From: Laura Gibbons
Sent: 04 April 2019 14:21
To: Planning.Responses
Cc: Stuart Corbey
Subject: RE: Planning Consultation on: BR/63/19/PL

Engineers Comments Regarding Surface Water Drainage

APPLICATION NO: BR/63/19/PL

Site Address: 15-17 Kew Gardens Bognor Regis PO21 5RD

Project:-			
Proposed Residential Development 15-17 Kew Gardens Bognor Regis West Sussex			
Title:-			
Proposed Site Plan			
Client:-			
Farnden Developments Ltd			
Scale:-			
1:100 (@A1)			
Drawn By:-		Checked By:-	
PJD			
Date:-		Date:-	
14/02/19			
Job.No:-		Drg.No:-	
180037		03

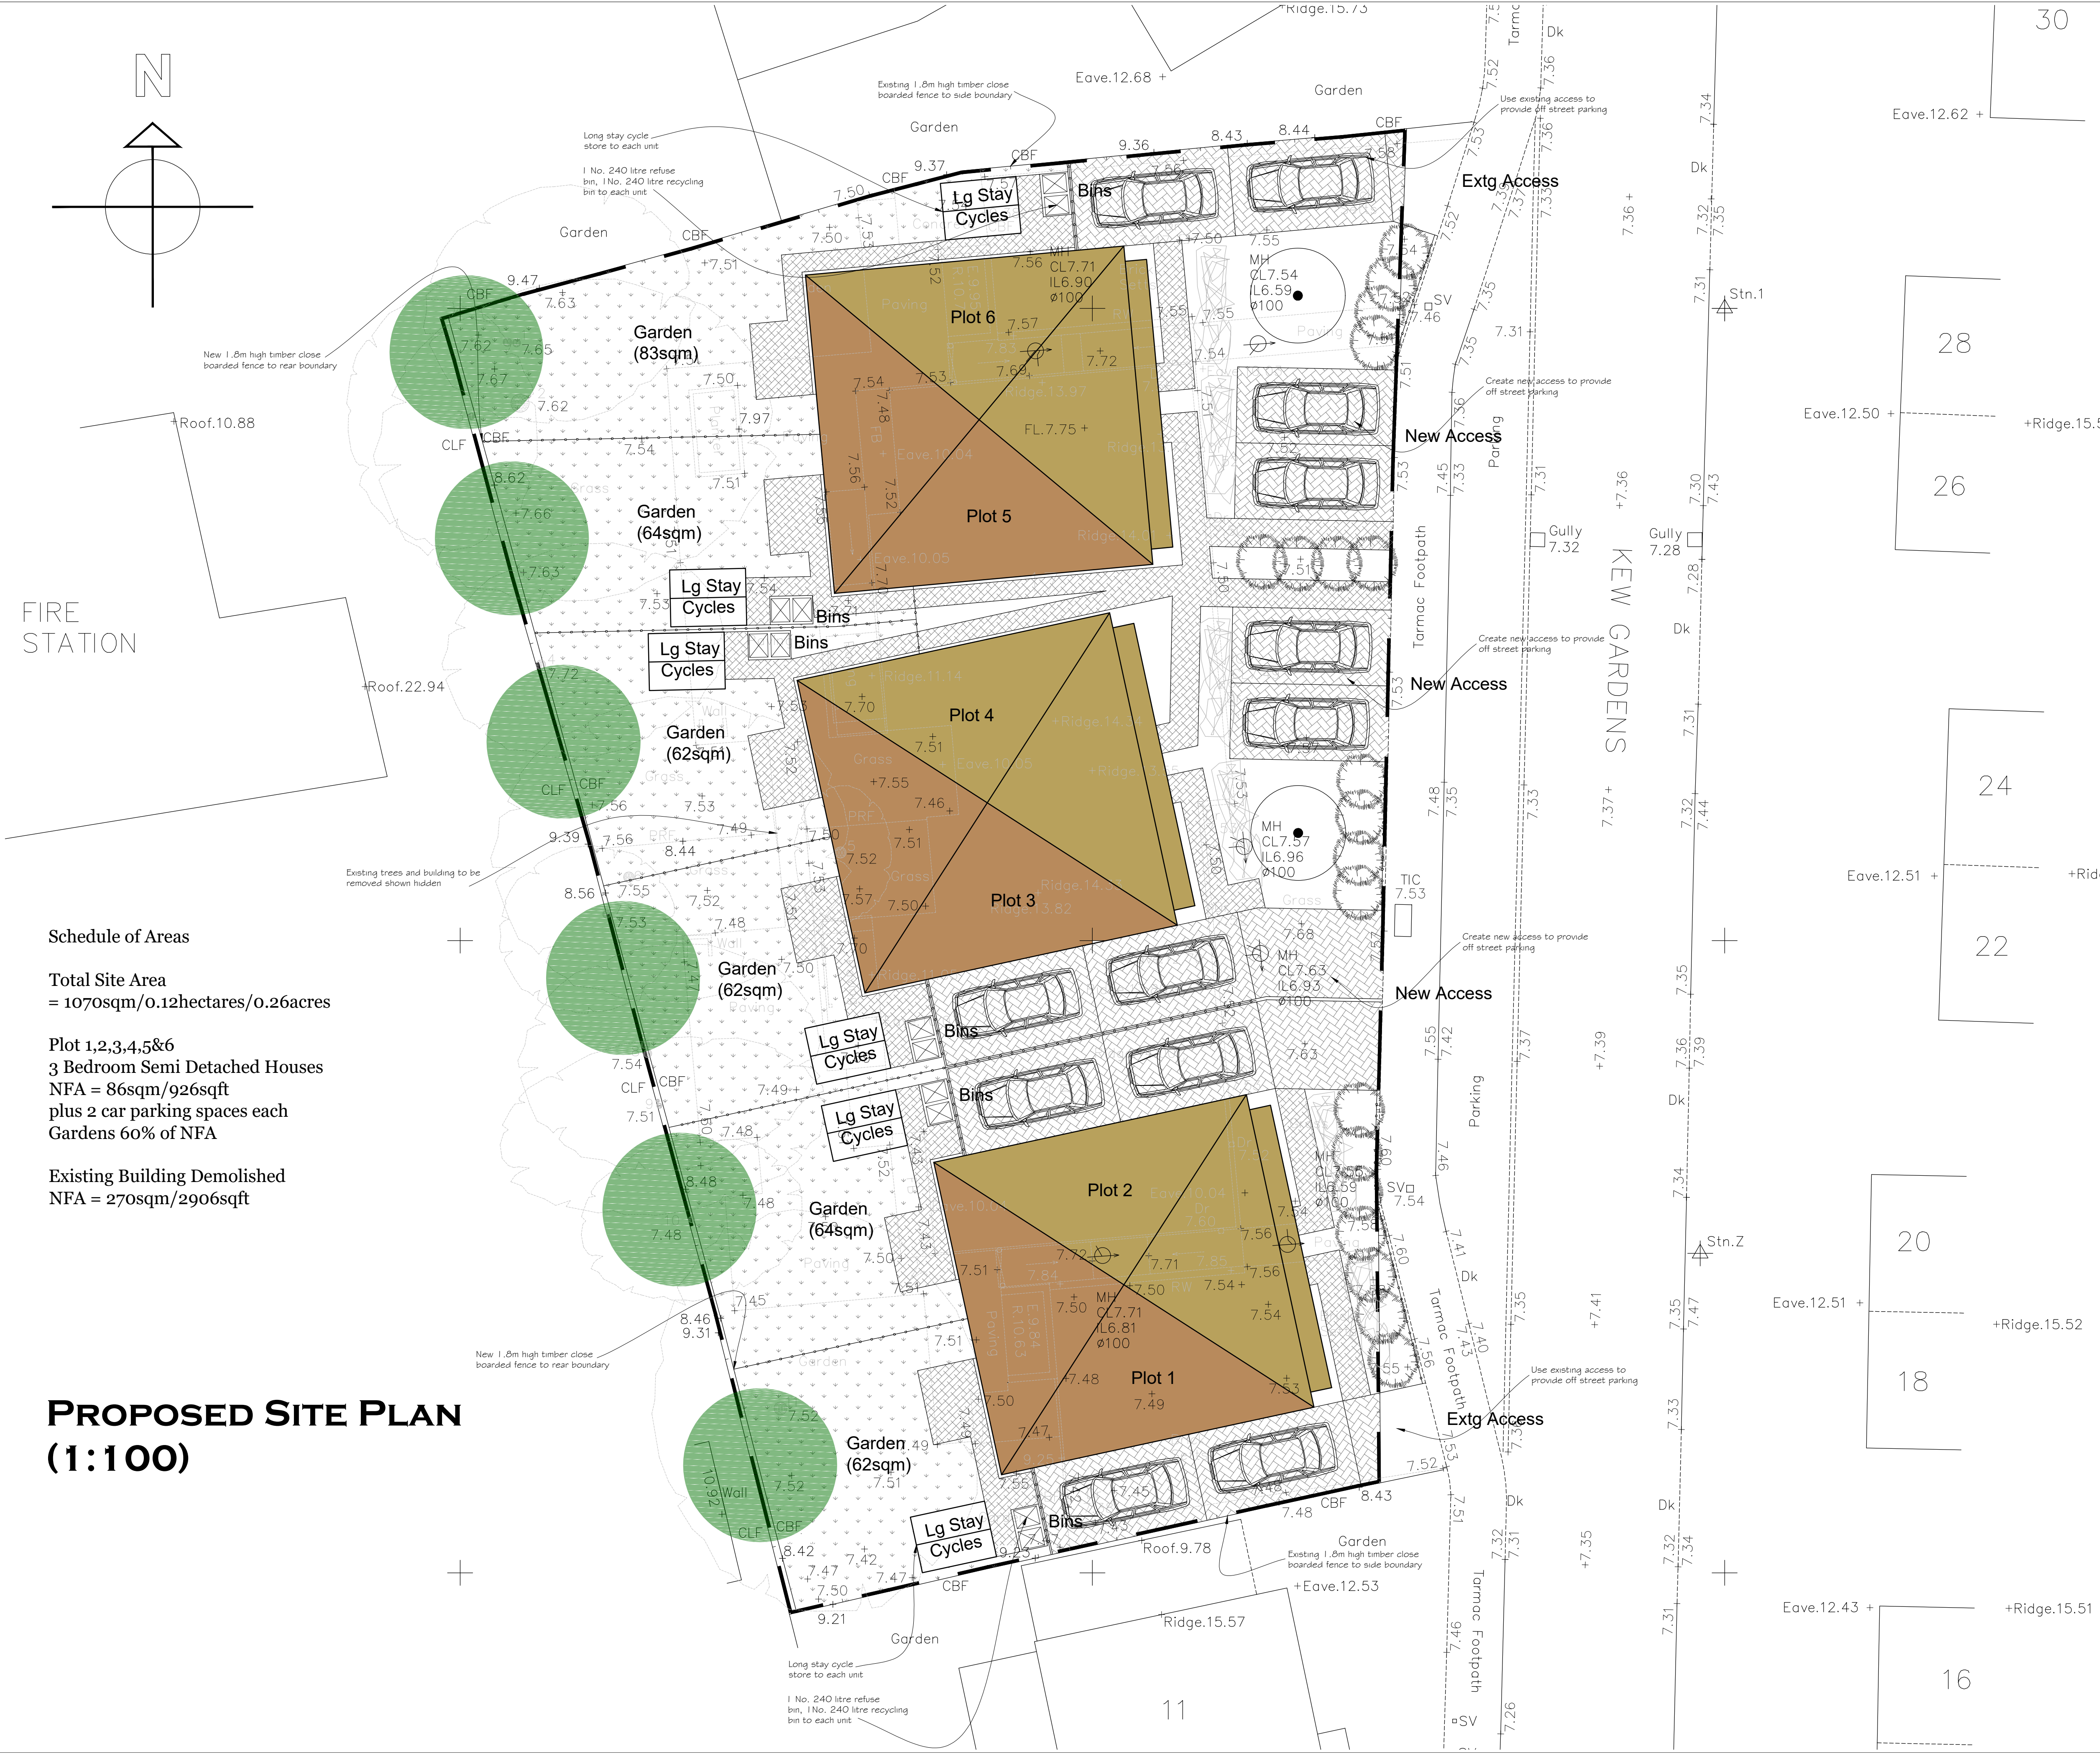
I object to the currently proposed layout due to a lack of space for surface water drainage.

Infiltration must be fully investigated, insufficient space for infiltration is not valid justification for not using infiltration. Soakaways must be located 5m away from buildings, and should be located 2.5m away from property boundaries. The proposed layout does not provide space given these requirements.

I hope that plans will be revised to provide more space for surface water drainage. Should this happen we would request the following conditions to be imposed.
